RESPONSE TO SUBMISSIONS – SSD 6513 MOD 3 BUILDING R1, BARANGAROO SOUTH

This letter has been prepared by Ethos Urban (formerly JBA) on behalf of Lend Lease Millers Point in relation to the section 96(1A) application (MOD 3) to modify SSD6513 being Building R1, Barangaroo South.

This letter provides a response to the submission made by the City of Sydney, dated 4 October 2017, and information requested by the Department of Planning and Environment (the Department) via email dated 3 October 2017. Each issue is addressed under separate heading below.

9.53
6061 T6
ALUMINIUM
PLATE

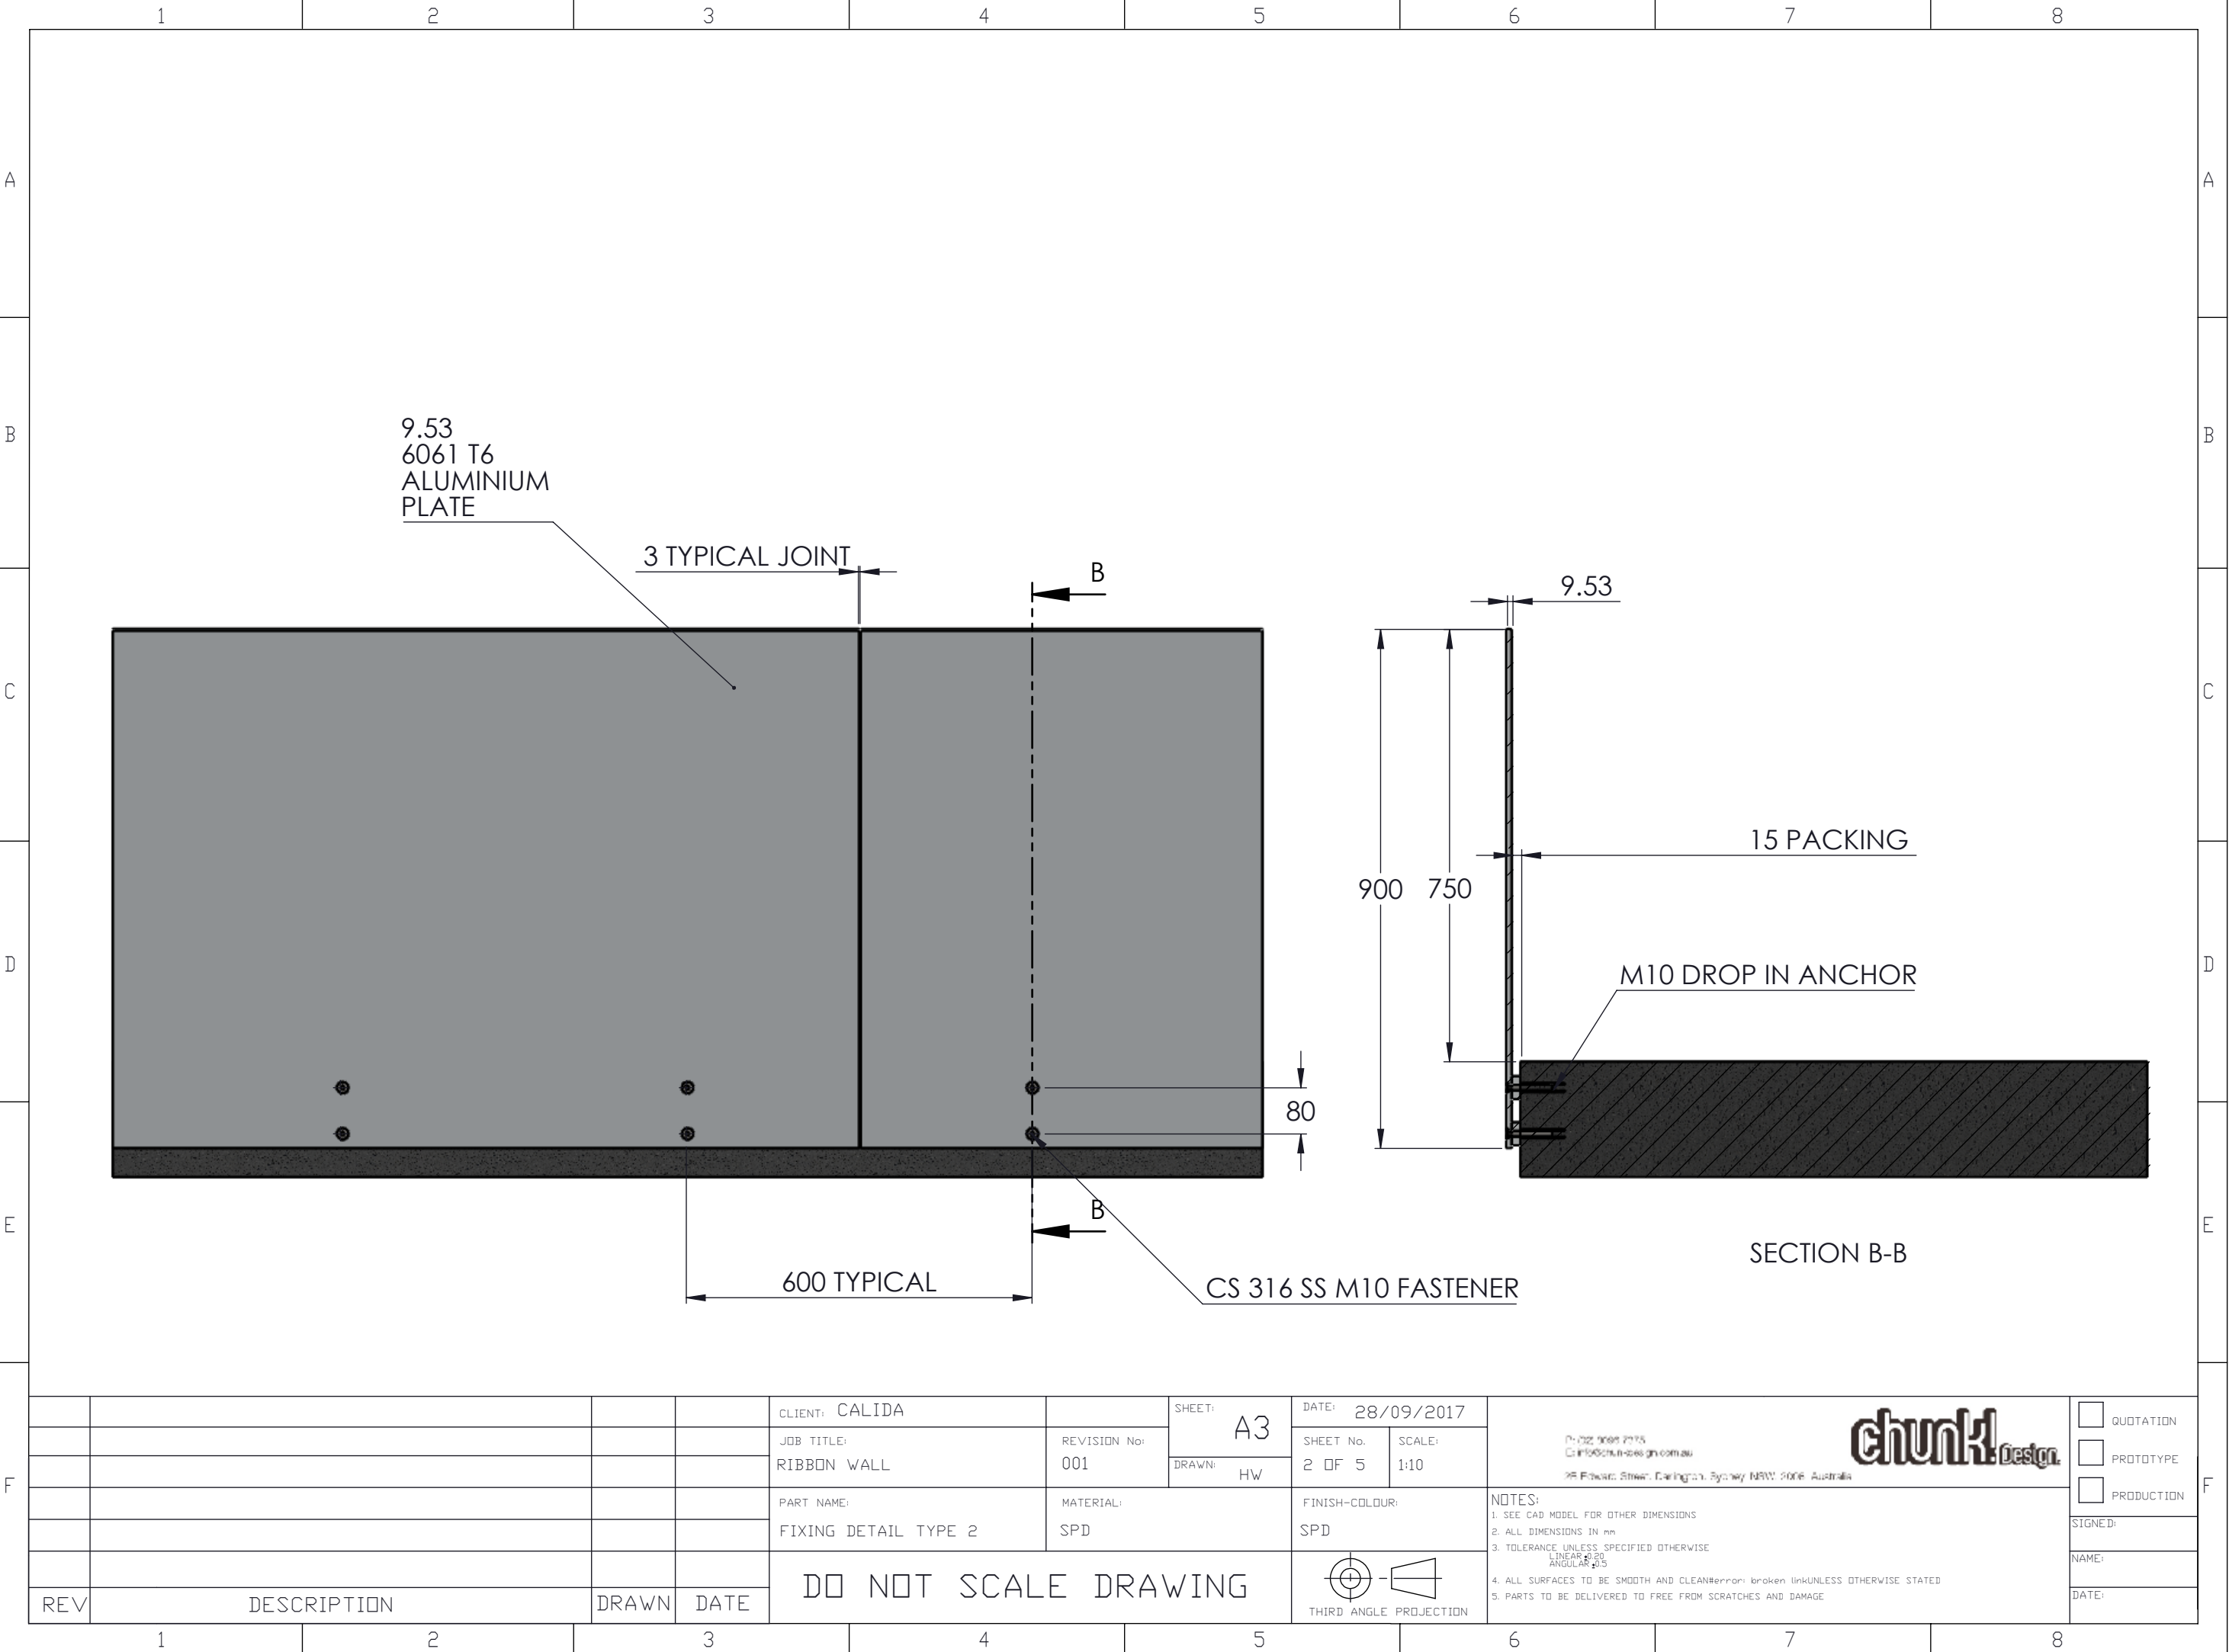
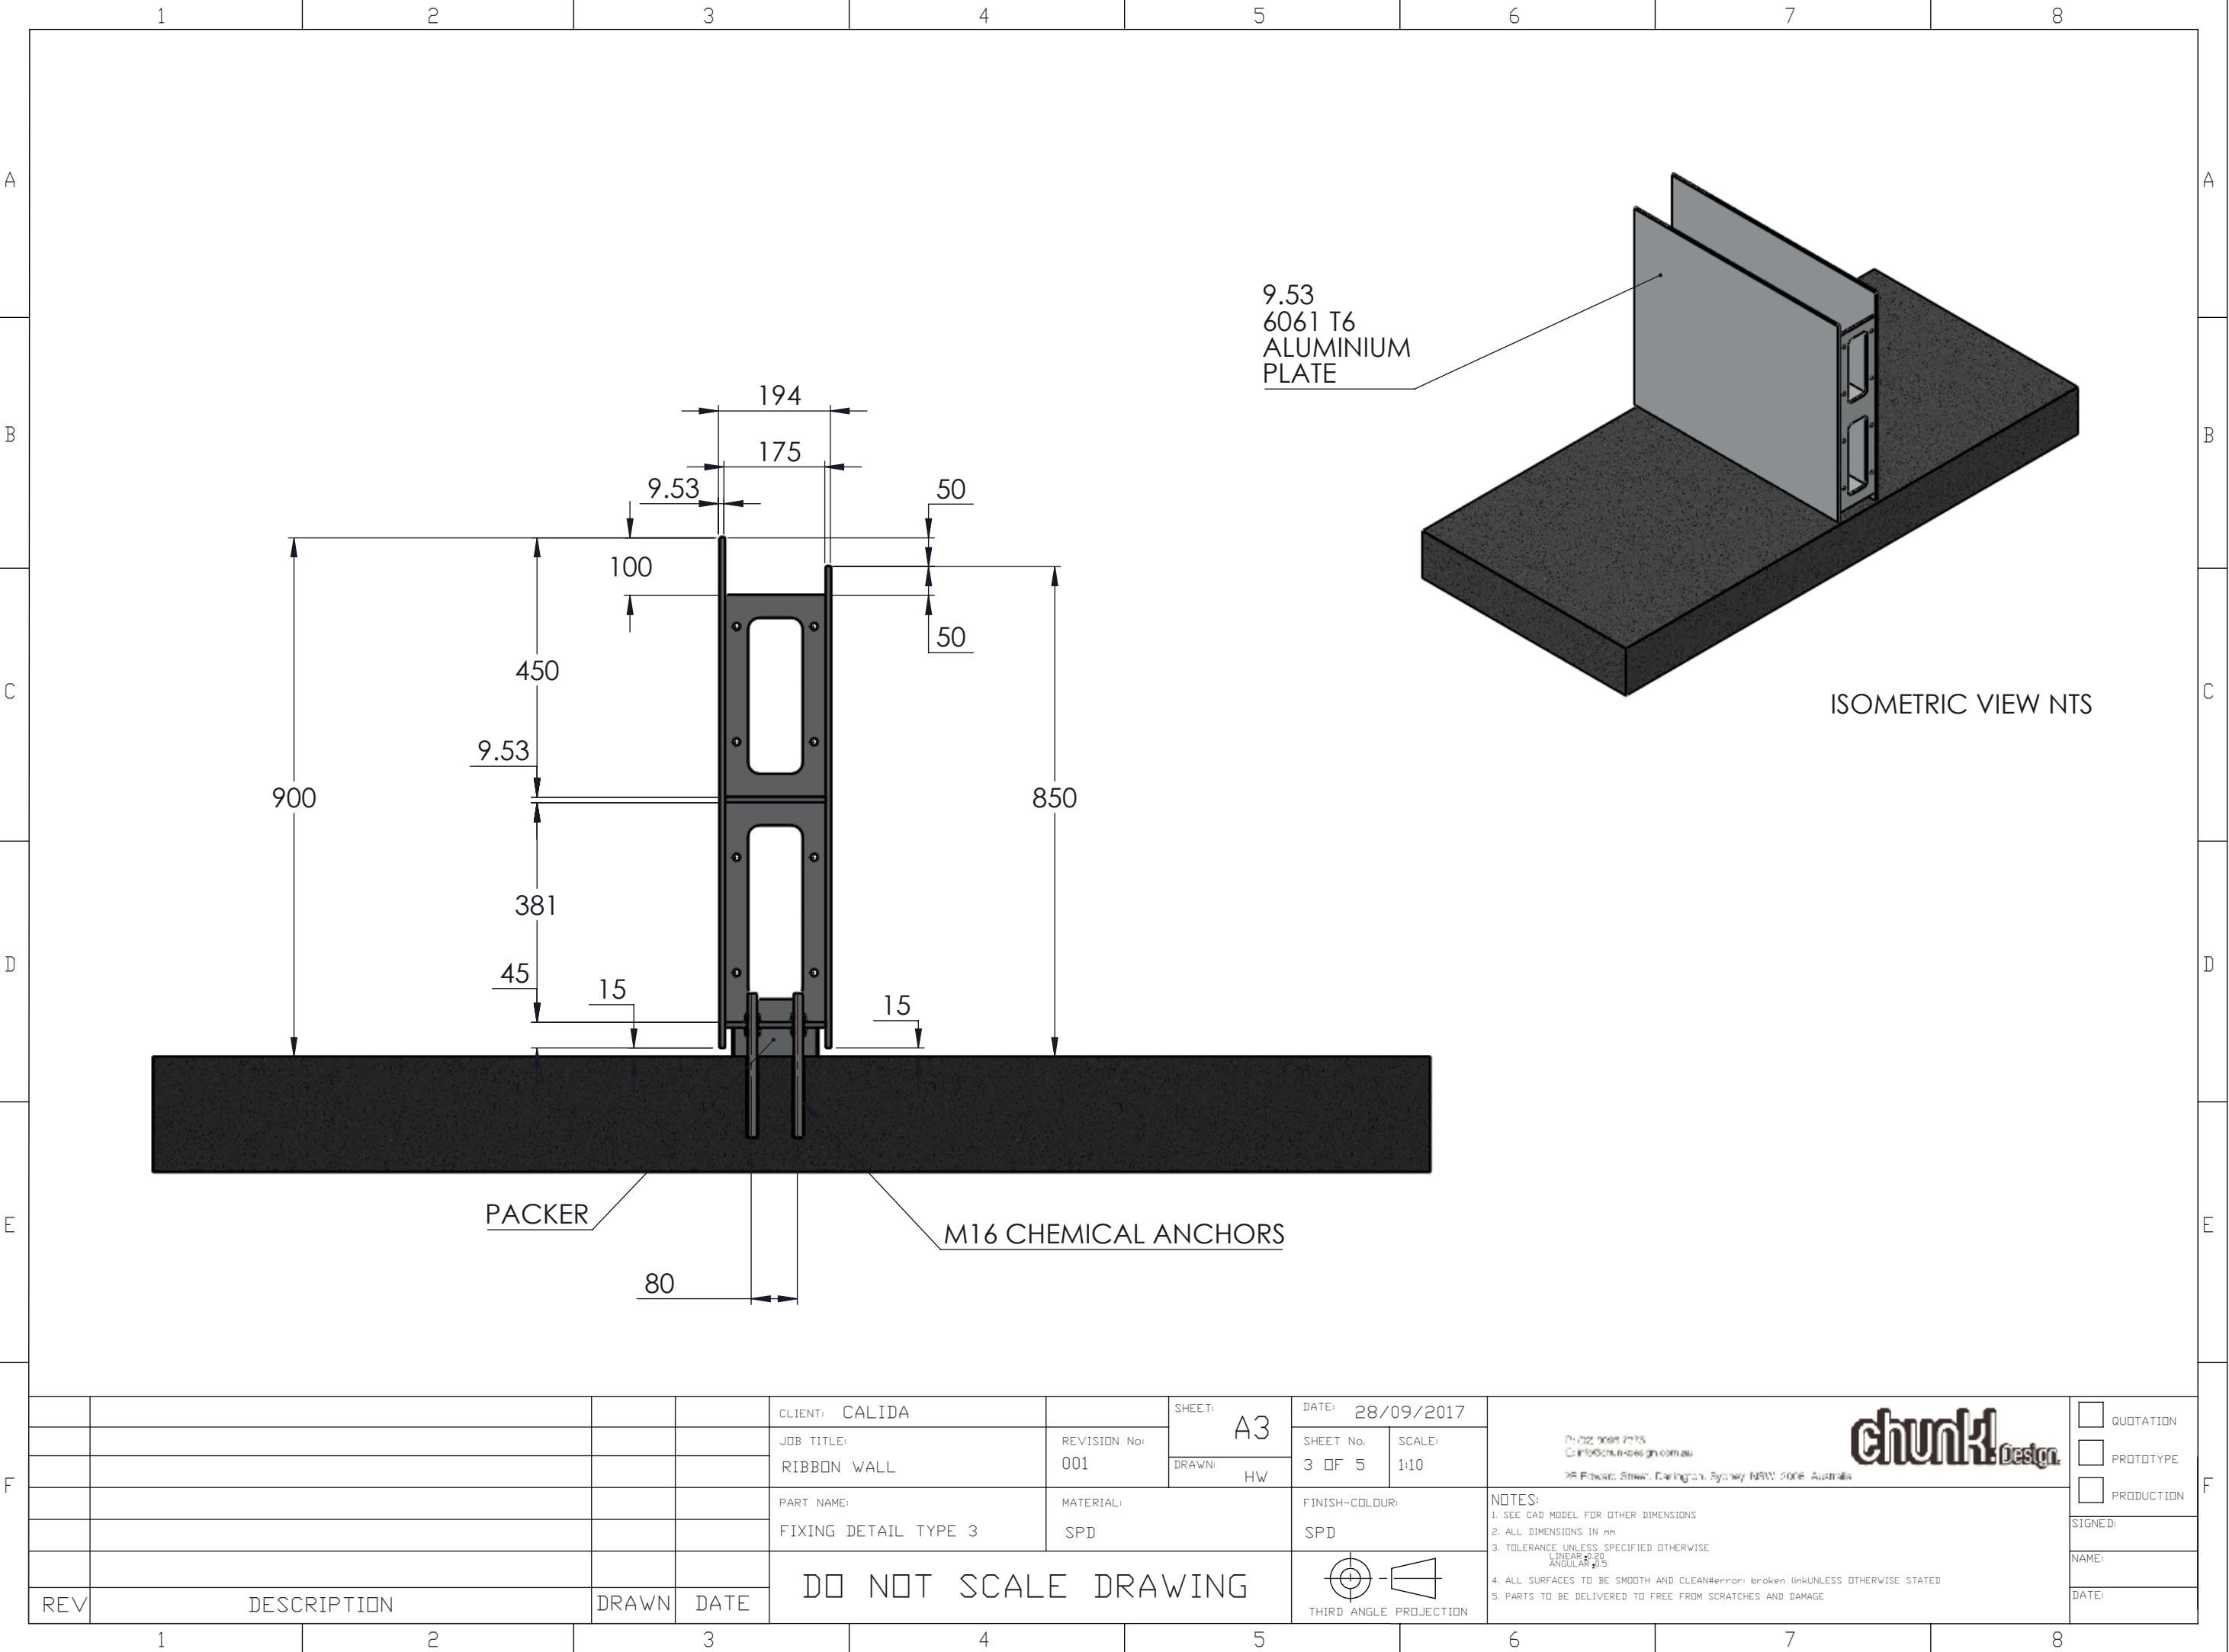
Folded Metal Planter Details

Additional 'for information' diagrams have been prepared and submitted at **Attachment A** to demonstrate the proposed installation of the folded metal planter boxes demarcating the outdoor areas of the ground floor seating from the public domain of Barangaroo South.
